Engineers Comments Regarding Surface Water Drainage

APPLICATION NO: AL/21/20/OUT

Site Address: Land North of Lee's Yard Lidsey Road Woodgate PO20 3SU

Description of Works: Outline application with some matters reserved for the erection of 38 No. dwellings consisting of 5 No. 4-bed house, 14 No. 3-bed houses & 19 No. 2- bed houses, with communal work hub & associated car parking & landscaping (resubmission following AL/57/18/OUT).

Dwg No. 1428A-SK-002

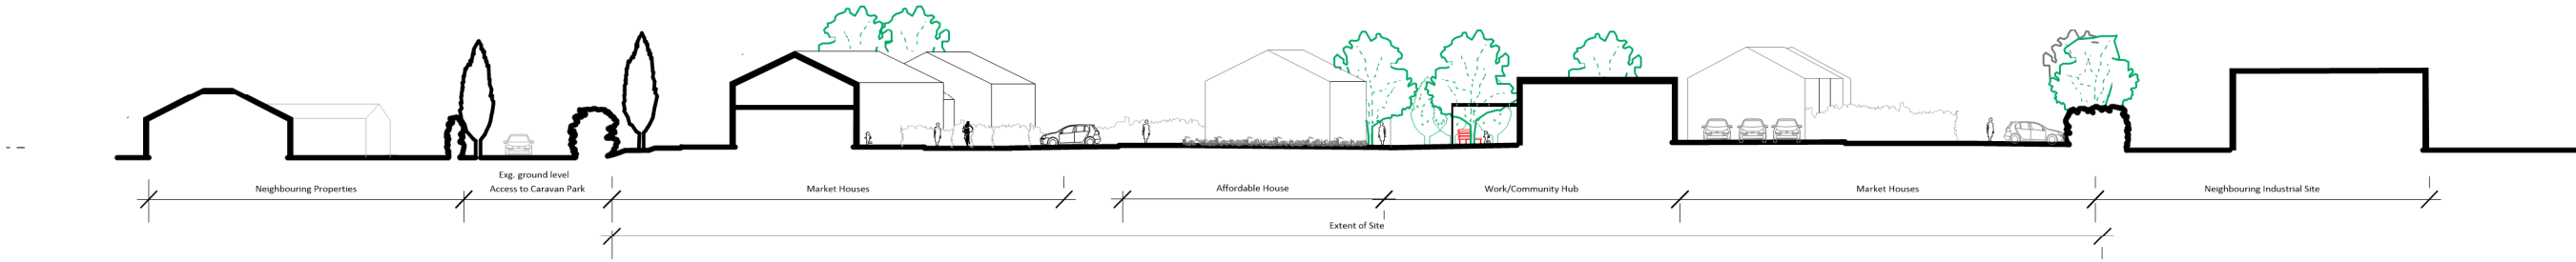
It should be noted that there is an area of surface water flood risk to the east of the site, any proposals to develop in this will need to be accompanied by evidence that development will not increase flood risk elsewhere and the risk to the proposed development is reduced, i.e.. Finished floor levels set to appropriate levels above flood levels.

There is a watercourse running to the east of the site, no development should occur within 3m of this. Any proposals to connect to a culverted watercourse will need land drainage consent, which can be sought through us.

It should also be noted that the current proposed discharge rate is unacceptable. The justification for a discharge rate of 4.9l/s based on the principles of blockage is insufficient, rates of 2l/s can be achieved.
